Application No: EP/167/21/HH
Site Address: 2 Vicarage Lane East Preston BN16 2SP
Description of works: Erection of single storey rear and side extensions with mono pitched roofs and installation of fencing to front and side.

Thank you for your internet representation made on 28th January 2022 which has been recorded as an objection with the comments as follows:

GA 004

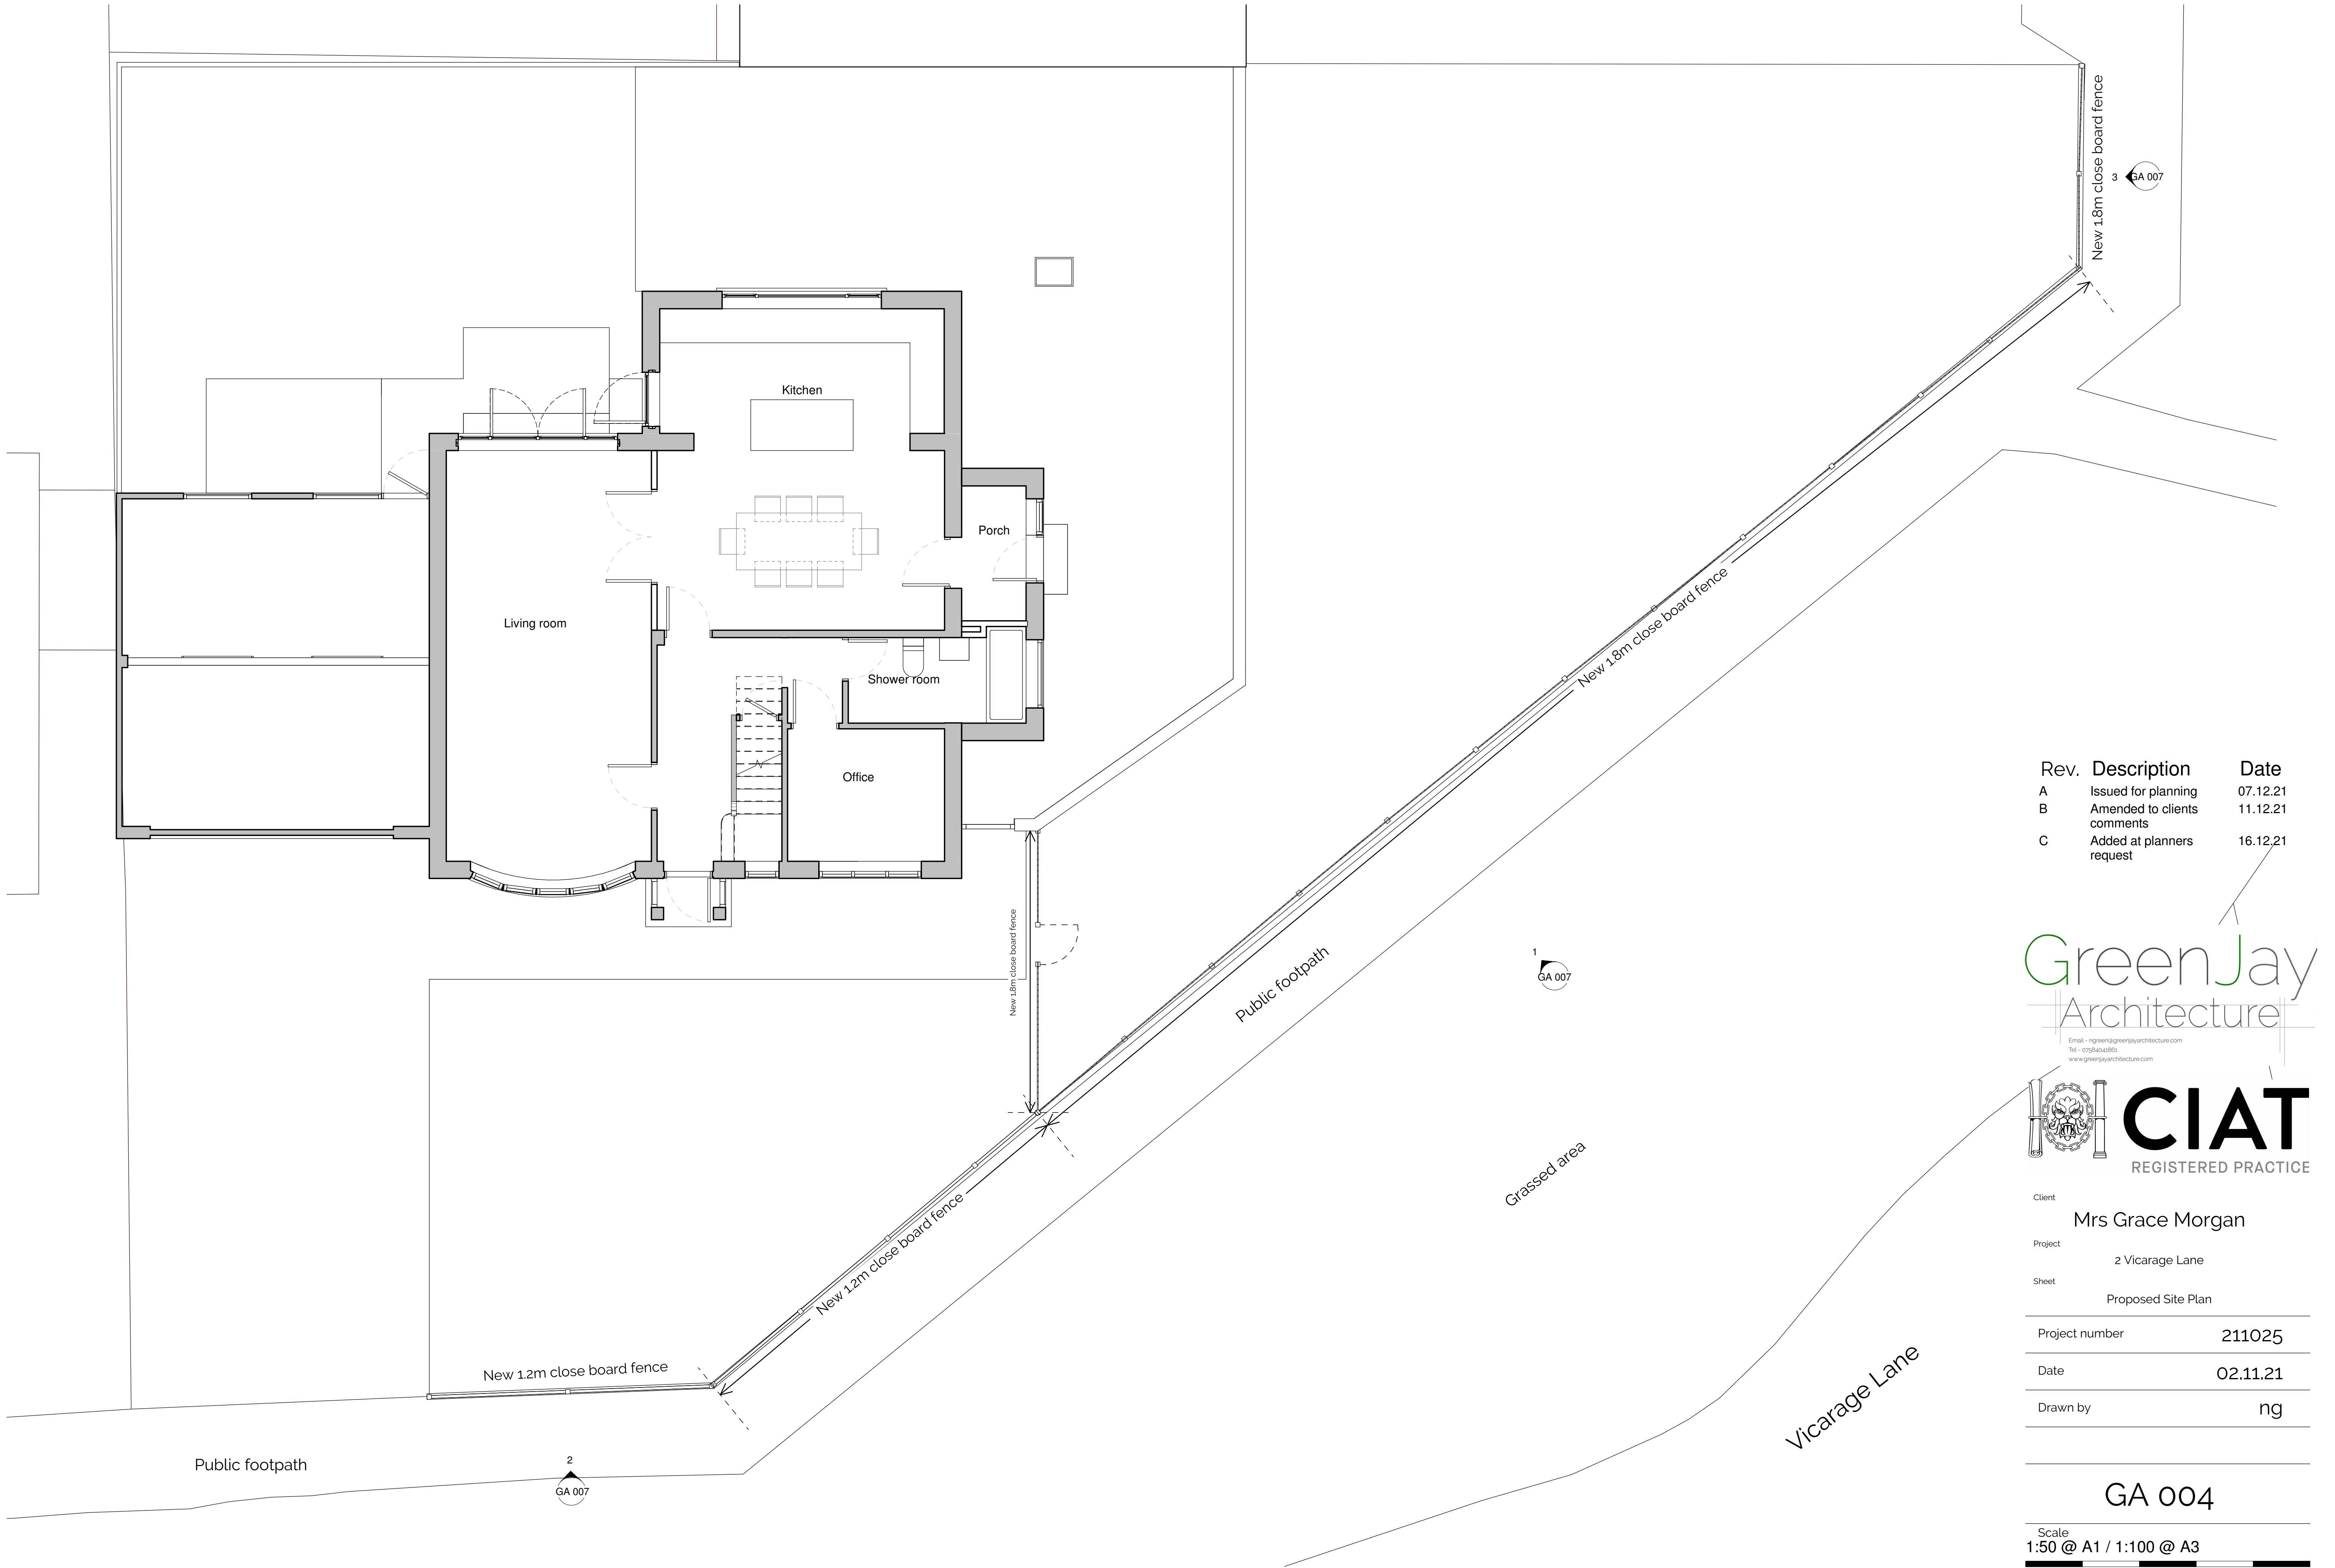
I write on behalf of the East Preston and Kingston Preservation Society. The single storey extensions proposed are unobjectionable. The Society does, however, object to the application to put up 1.8m or 2m high close board fencing along the greater length of the boundary of this prominent and open corner plot. Most properties along Vicarage Lane have border hedges, or lower fences or walls with vegetation behind them. Such a length and height of stark close board fencing is inappropriate for the area. As part of a development built in the third quarter of the twentieth century no.2, Vicarage Lane should be considered alongside these similar properties as typical of Character Area 1 described in the East Preston Neighbourhood Plan. Thus Policy 2i - the preservation of the street scene - applies, and consideration should be given to paragraph 4.26 "- the construction of high walls or fences should be resisted. The character of this area is largely created by the green appearance of the roads which should be preserved." Hedging or shrubs would be a far better barrier than the high fencing proposed, would encourage biodiversity, and would be more effective protection against traffic noise and pollution. The Society therefore asks that the application for the fencing be refused.
